# CITY OF ALBUQUERQUE

PLANNING DEPARTMENT – Development Review Services

September 9, 2015

RE: **Los Diamantes Subdivision  
Drainage Report, and Grading and Drainage Plan  
Engineer's Stamp Date 8-26-2015 (File: N09D013)**

CITY PROJECT NO. 722778 ZONE MAP NO. N-9-Z SHEET 1 OF 1

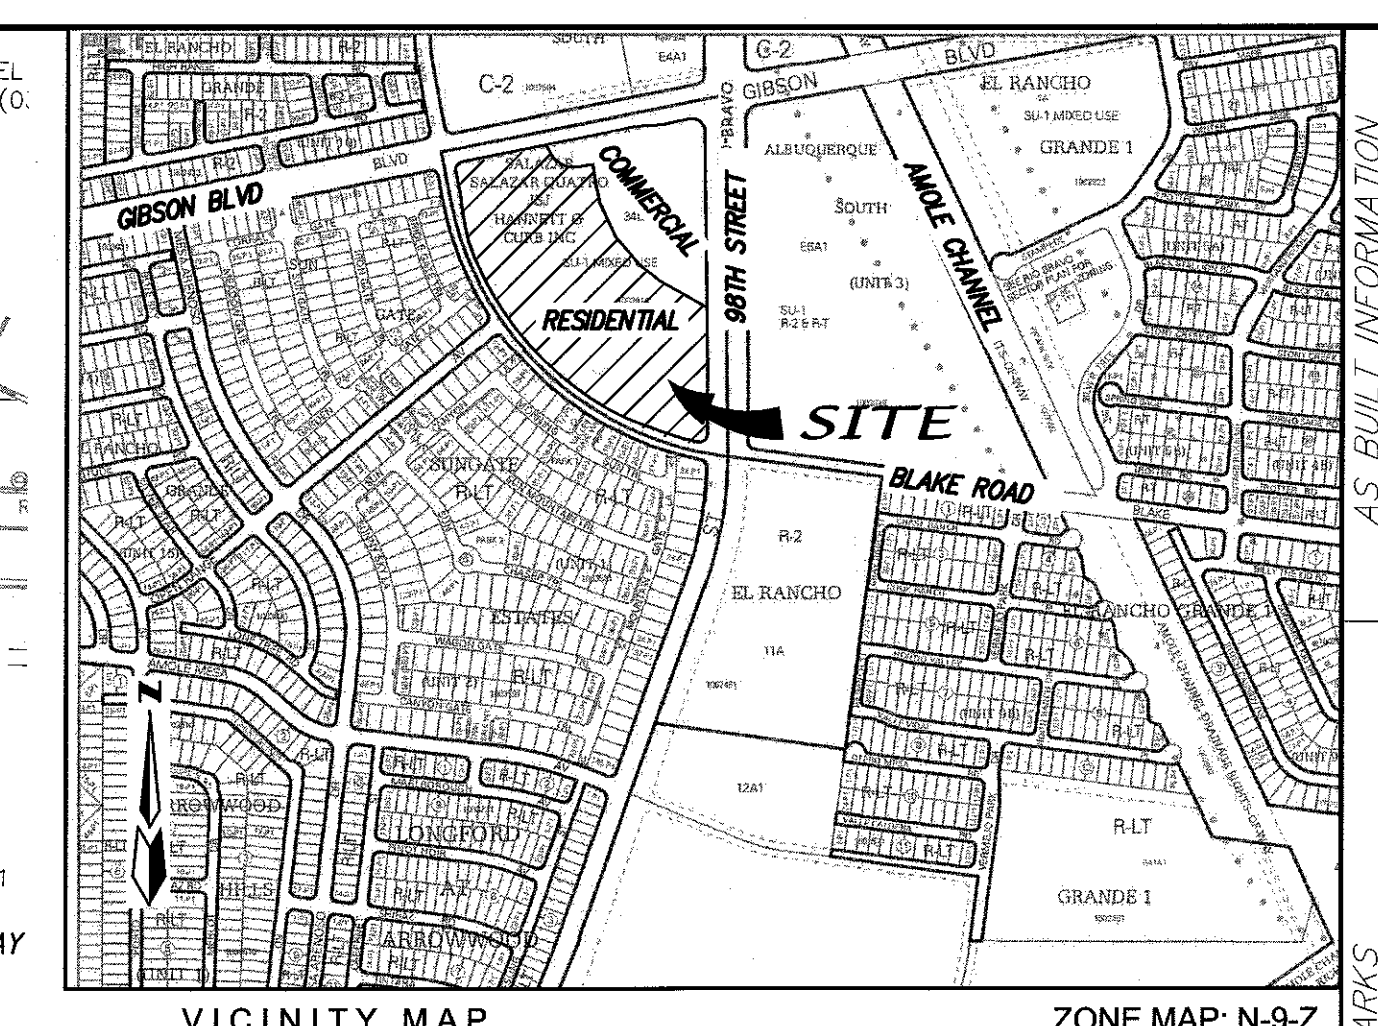
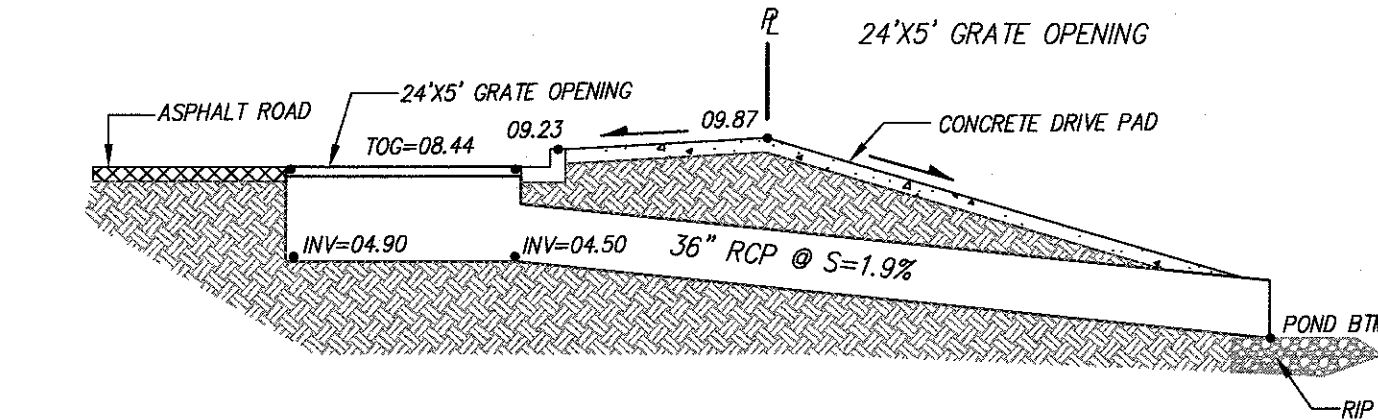
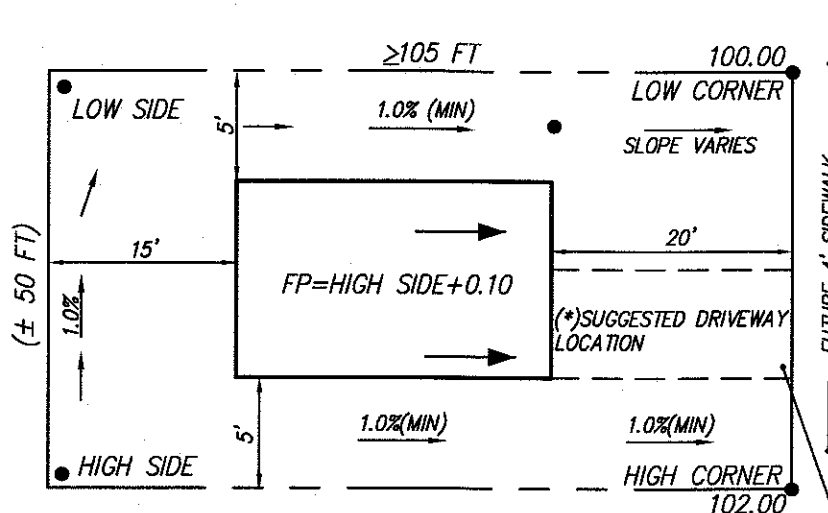
1. Temporary Pond on Tract A: Side slopes (2:1) must be stabilized with a more stable material. Per your email on 9/8/15 you will be changing it to a 3:1 slope with gravel mulch. This change must be reflected on the Engineer's Certified Plan.
